**ExQ3.3.1** Response from Mary Rance: 20031504. Deadline 6

I would like to thank the ExA for bringing this matter to my attention. This relates to plot numbers 2/5, 2/6 and 2/6/1. The Applicant's agents, Gateley Hamer, have sent me 2/6 which incorporates 2/6/1 also. I have not been sent 2/5 at any point.

Drawing Title  
**LAND PLAN IN ACCORDANCE WITH REGULATION 5(2)(i) OF THE INFRASTRUCTURE PLANNING (APPLICATIONS: PRESCRIBED FORMS AND PROCEDURE) REGULATIONS 2009 SHEET 2 OF 9**

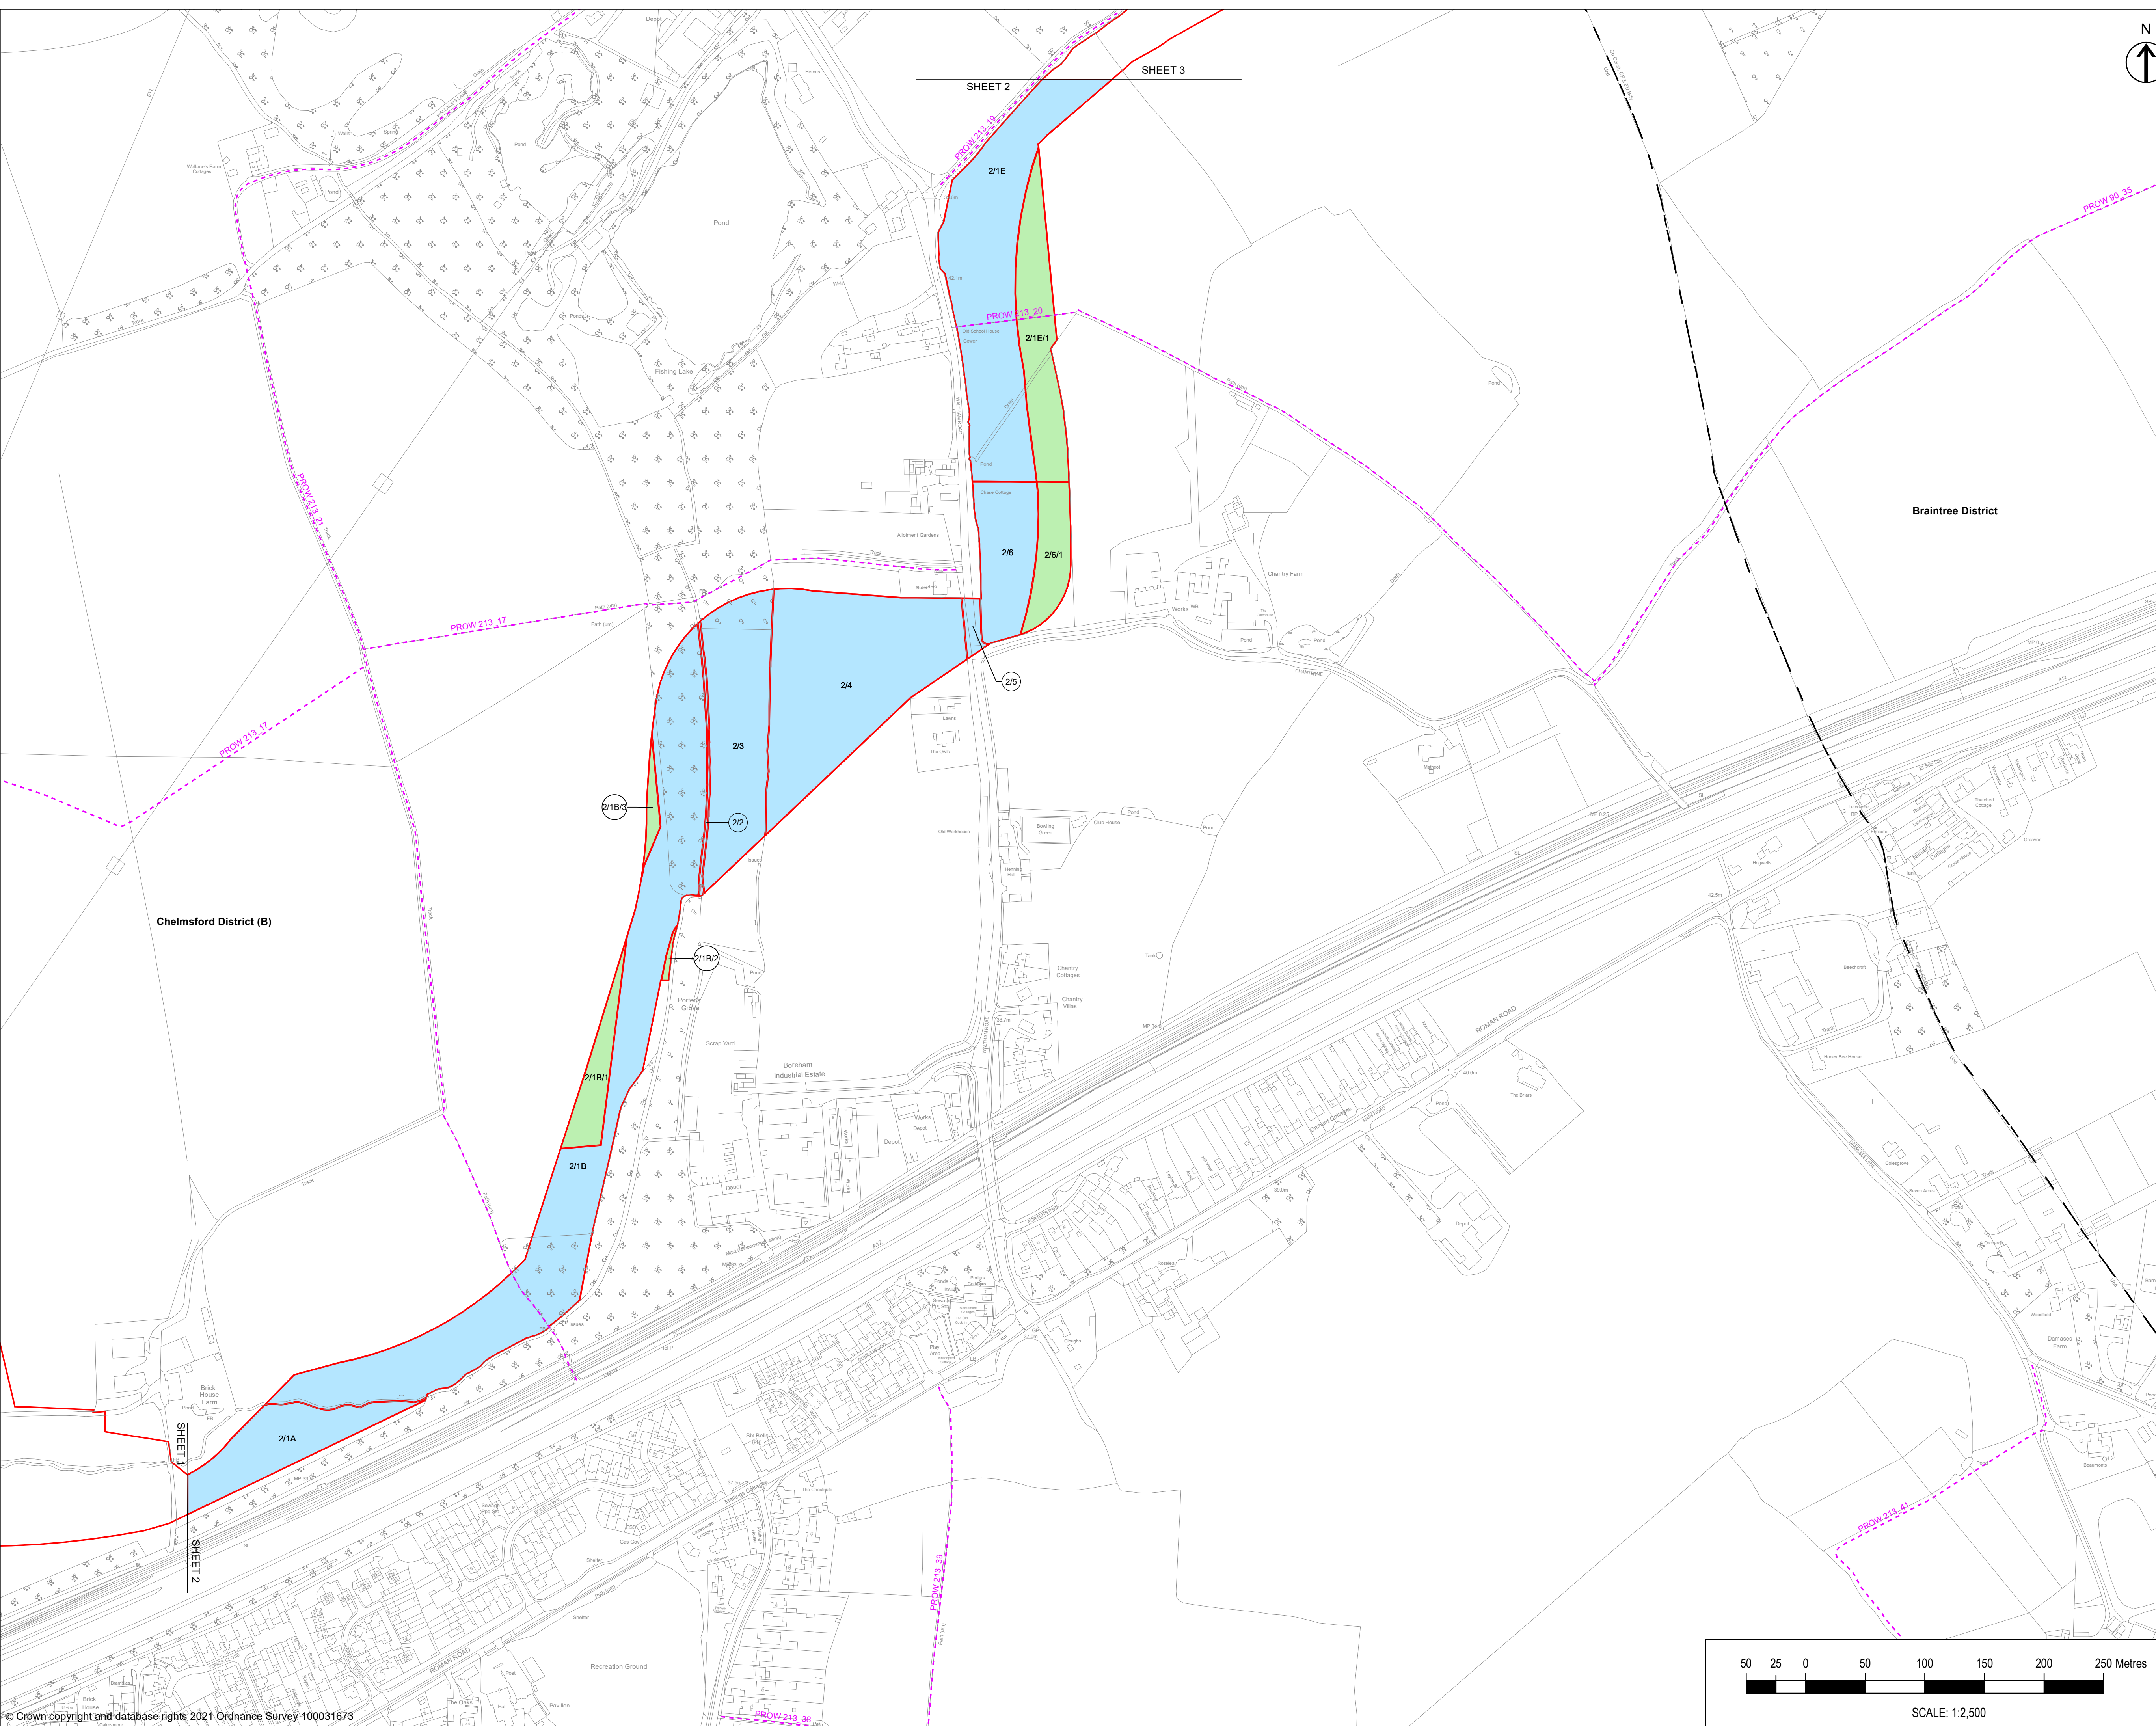
I am still waiting to receive from the Applicant details of their proposals in relation to plot 2/5. However, based on the limited information that I have, I am objecting to the southern boundary line which impedes part of the entrance to Chantry Lane, covers the current visibility splay of Chantry Lane and any structure within the verge is likely to impact on the visibility splay. It also covers the area where the mains water is connected to the Chantry Lane supply. There are two meters there.

One of the modifications which are being sought for 2/6 is that the easement area should not cover the entire length of the field (from north to south) but should stop several metres short of the southern end, leaving that corner of the field to me. There has been no indication regarding the western hedge line, which contains mature trees – I have asked the Applicant for clarification but, if the proposals do include the trees, I would expect this to be addressed in an arboricultural survey to ensure that there is no adverse impact or adverse long-term harm to the trees and hedgerow and their root protection areas.

One detail that appears on my copy of 2/6 is the indicative trench line, very close to the boundary hedge, and it turns to cross the road (Waltham) well short of the south boundary of the field. If this position is found to be feasible, why would it be necessary for the Order limit to extend to the position shown on 2/5?

I am in direct opposition to granting access to the field on the corner of Chantry Lane. The Applicant is approaching from the northern end of the field and laying a temporary hard surface for vehicles, and I wish any access to be from that end of the field. Any access to the field from the corner of Chantry Lane would cause unacceptable upheaval and mess.

I am concerned about the plans presented for the works in this area; they are close to existing mature trees and hedgerows and are completely lacking in any detail. This should be

addressed to ensure that there is no adverse impact or adverse long-term harm to the trees and hedgerow and their root protection areas and no materials are stored in the root protection areas.
